RE: Lot 2 Elm Grove Villa - Smith Plumbing & Heating; Water Quality Detention Pond Certification

Lot 2 Elm Grove Villa  
Water Quality Detention Pond Certification  
September 12, 2024

DRAINAGE LEGEND

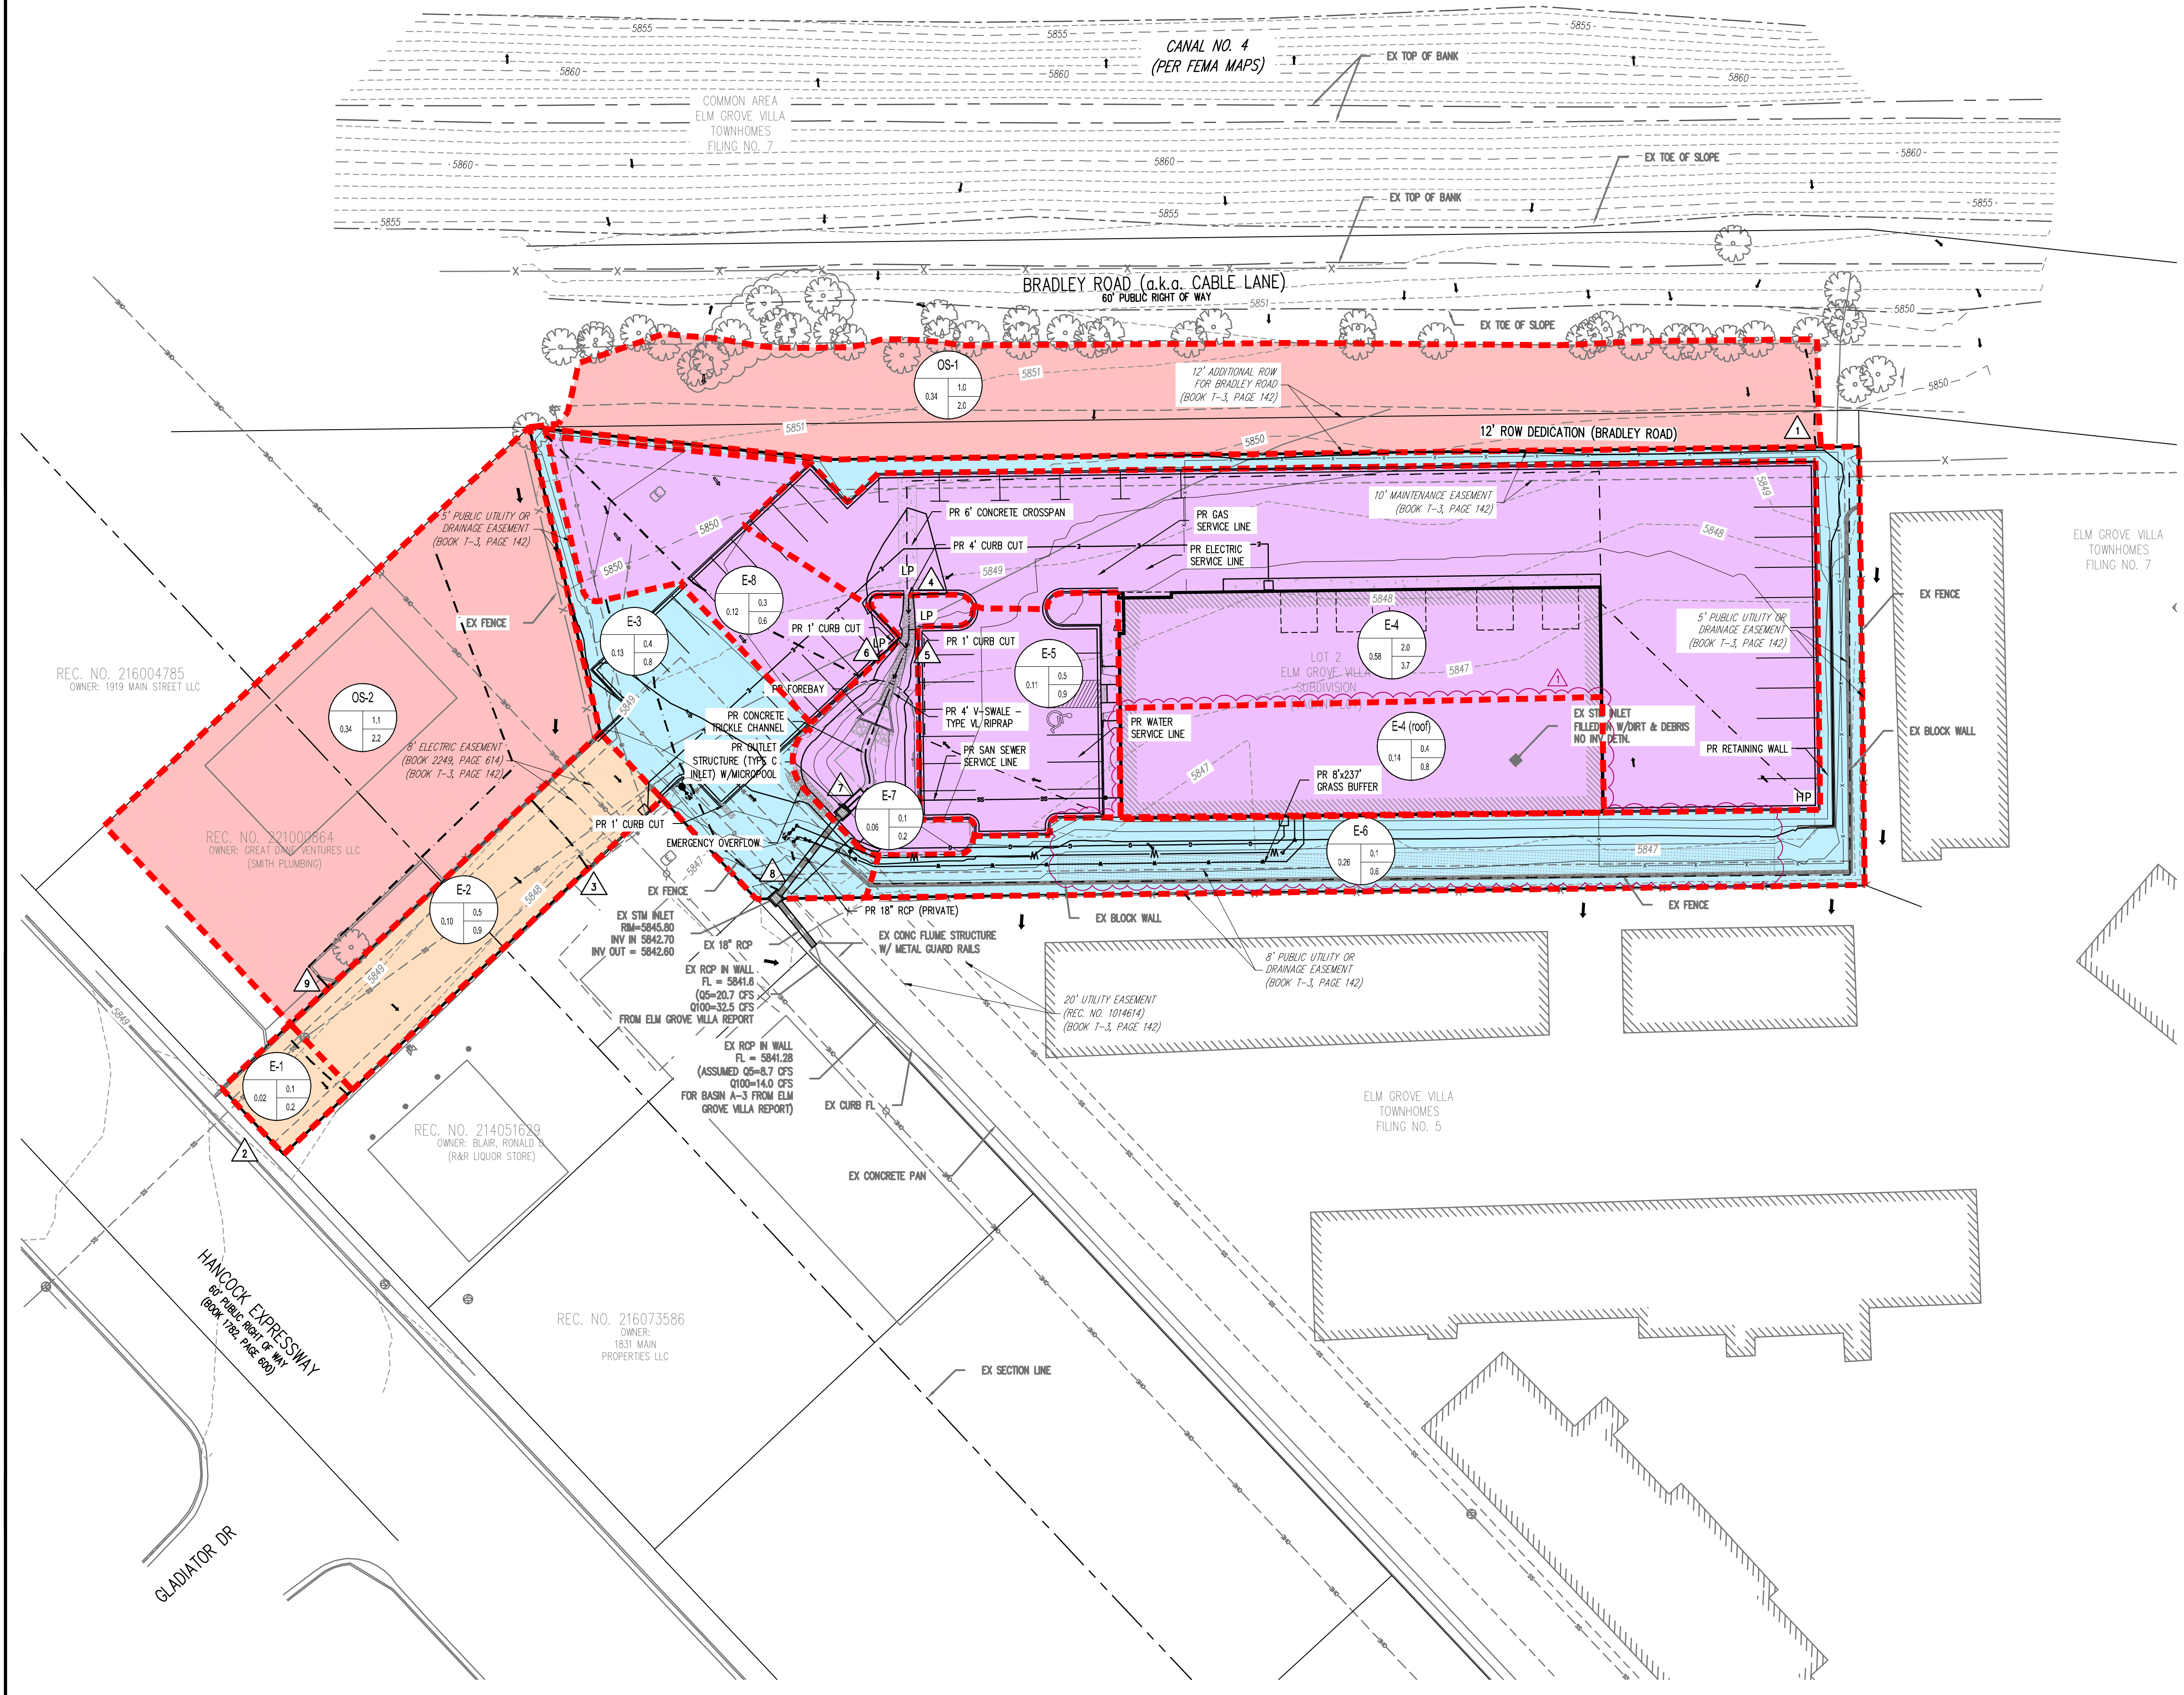
Please put a red line through this text so that it is clear that the grass buffer has been removed.

Now that you show all of E-6 as light blue, the excluded area per ECM App I.7.1.C.1 in light blue and orange exceeds the allowable 20% of the total disturbance. The SPA should just be given its own color and added to the Legend so that that 20% exclusion is not exceeded.
